**MALTESE POINT -
ROLLING THUNDER
PEYTON, CO**

SHEET TITLE:
LANDSCAPE PLAN

PCD FILE NO.
PPR 2414

LS1.0

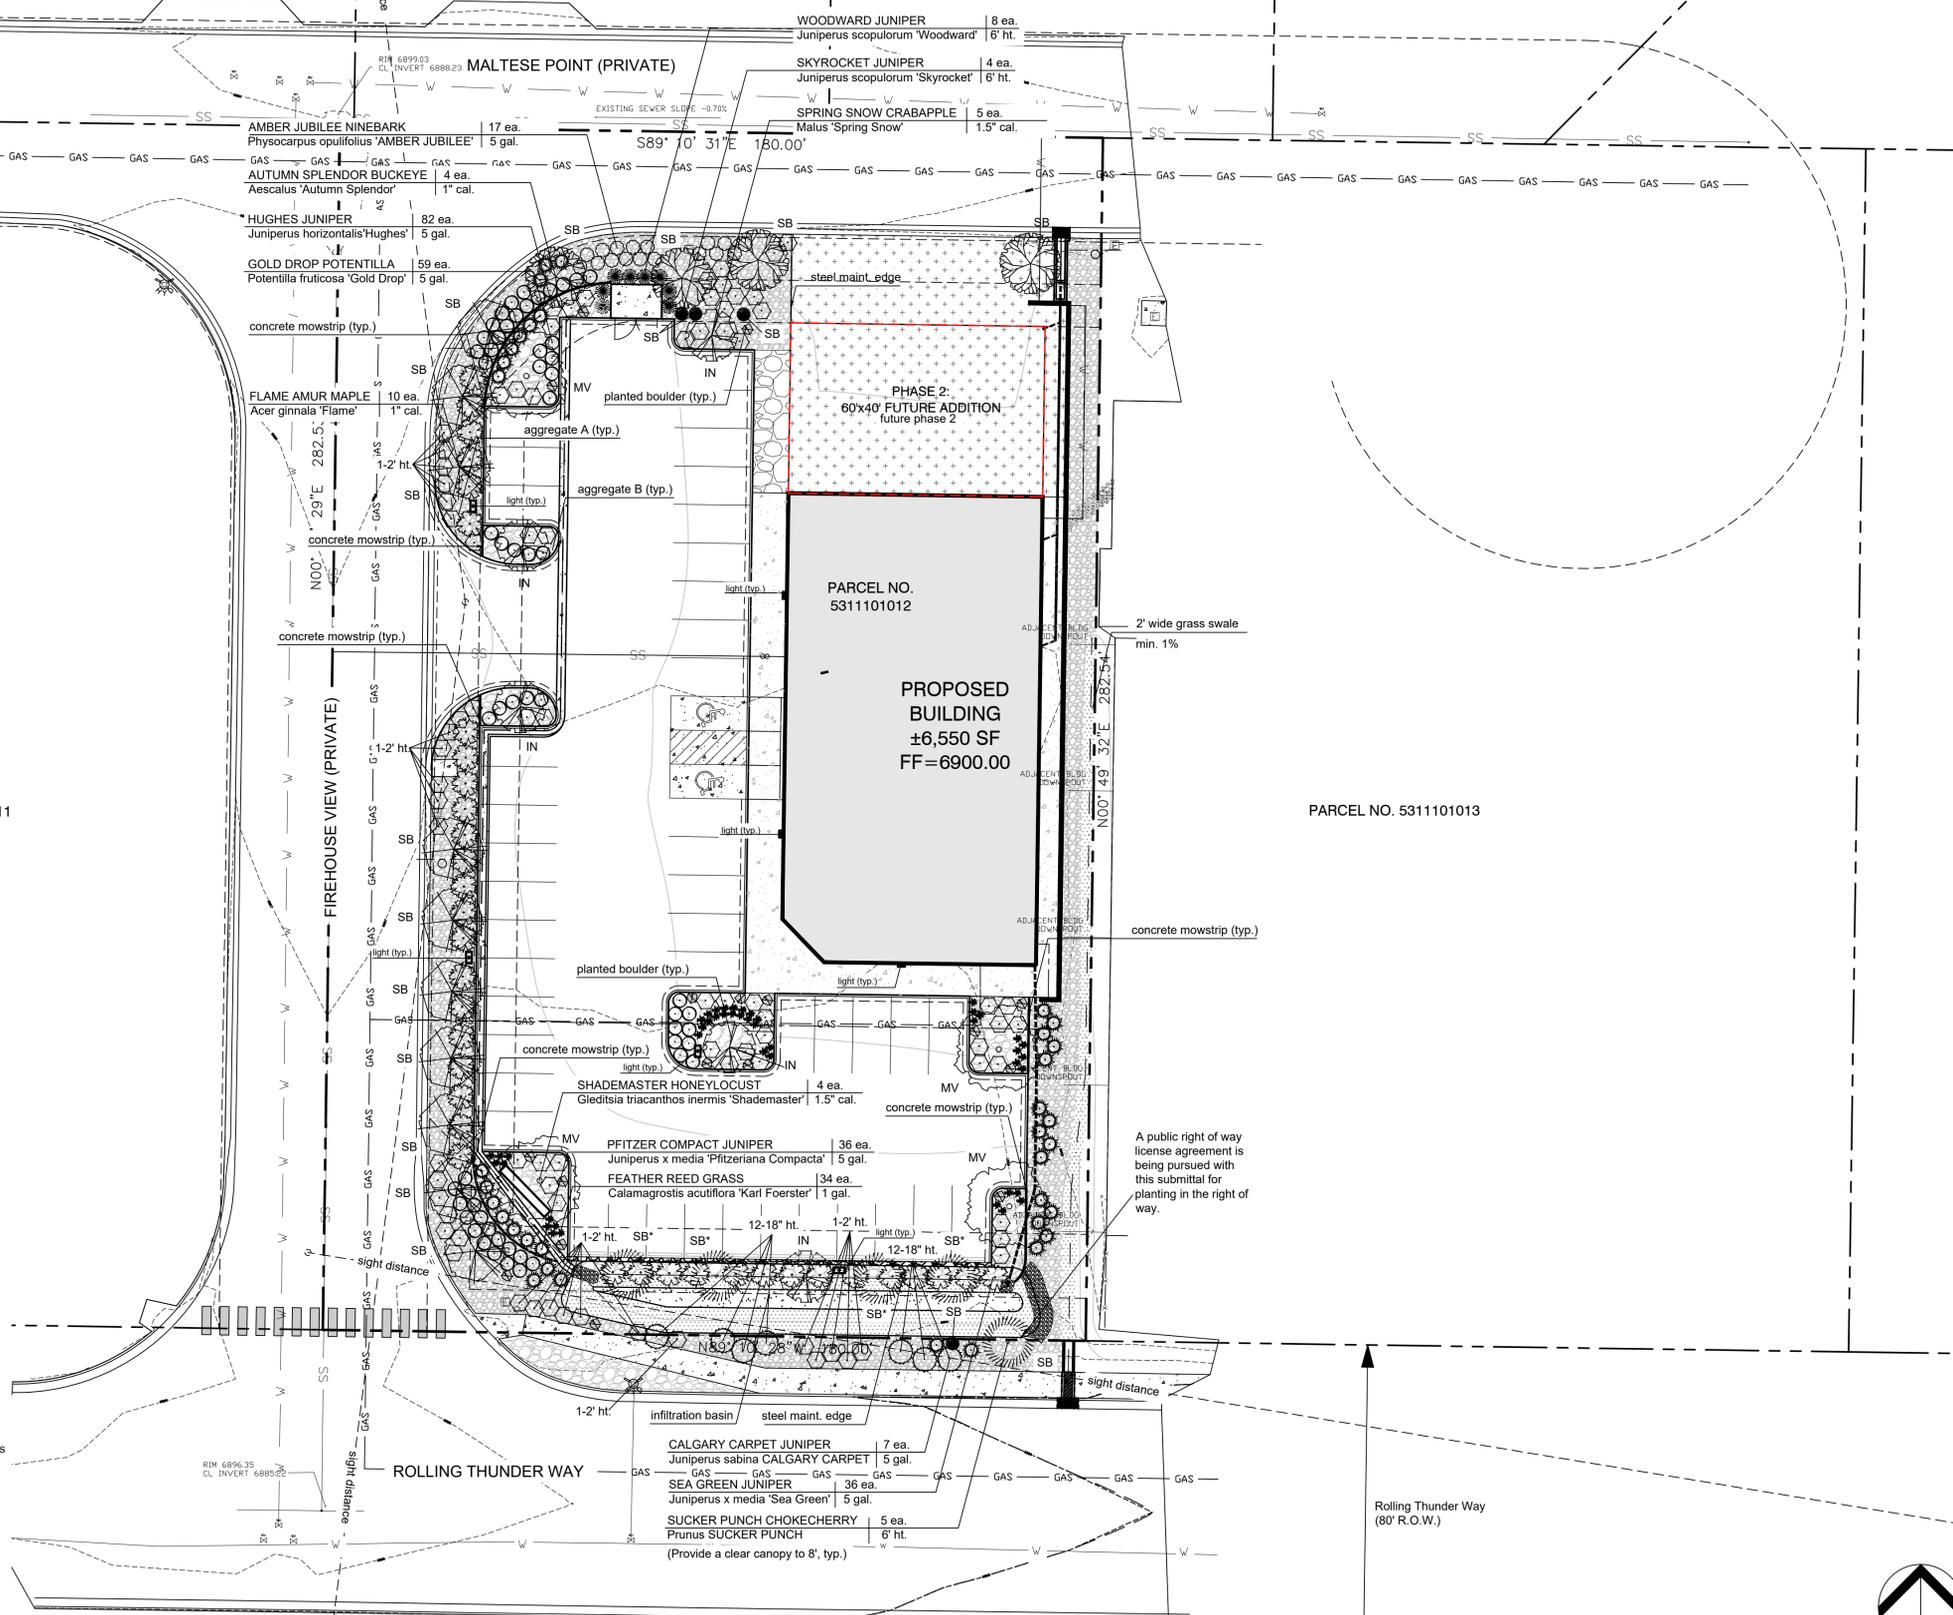
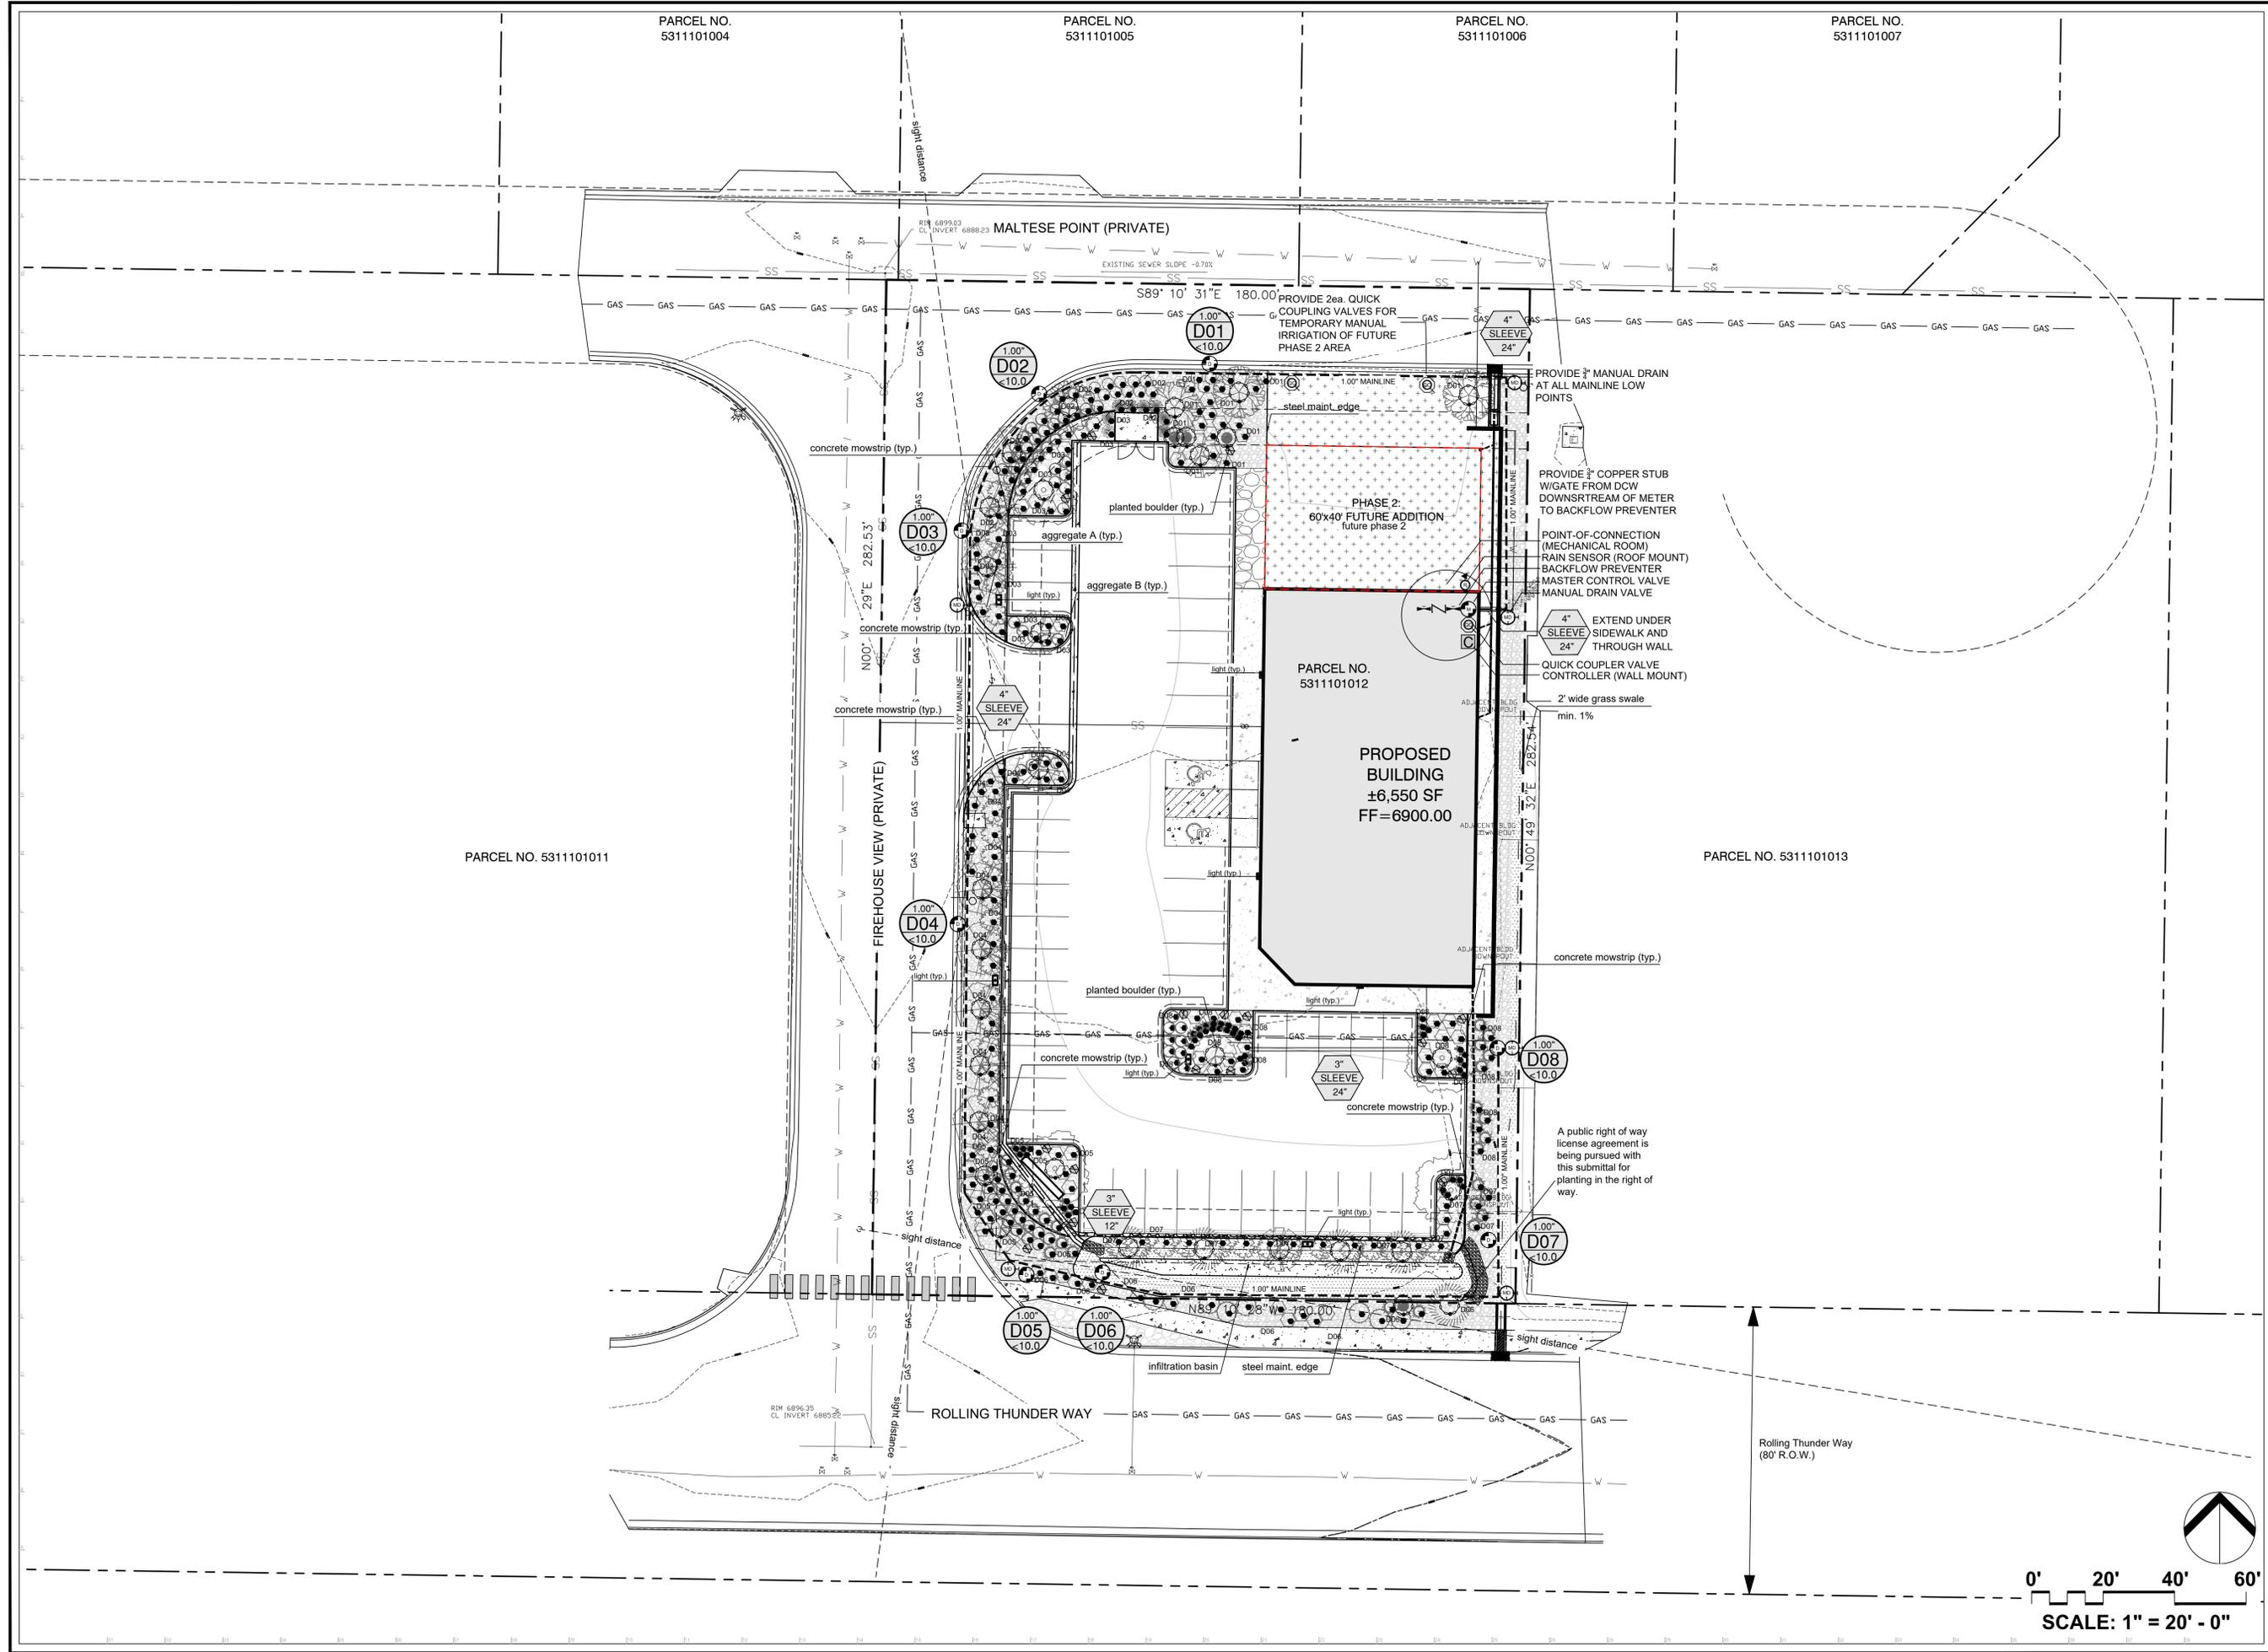
Per Section 6.2.2.C.1. "A tree of a type suitable for parking lots shall be provided for every 15 parking spaces in parking lots with 15 or more parking spaces. The required trees may be clustered and shall be located in a manner which will divide and break up expanses of paving and long rows of parking and create a canopy effect over the parking lot."

Per Section 6.2.2.C.2. "The most common method to satisfy the parking lot tree requirement is through the utilization of plant islands, fingers (areas open to the parking on 3 sides), and corners (open to the parking on 2 sides). Islands, fingers, and corners are required to be incorporated into all parking lots of 15 parking spaces or more in area. 1 island shall be provided for every 15 spaces. An island, finger or corner must be a minimum of two parking spaces in size (18' x 18' or 9' x 36' in order to qualify as a required island, finger, or corner."

See comments on the provided License agreement

This will need to be shown prior to approval, most specifically for the landscaped area within the right of way

A public right of way license agreement is being pursued with this submittal for planting in the right of way.
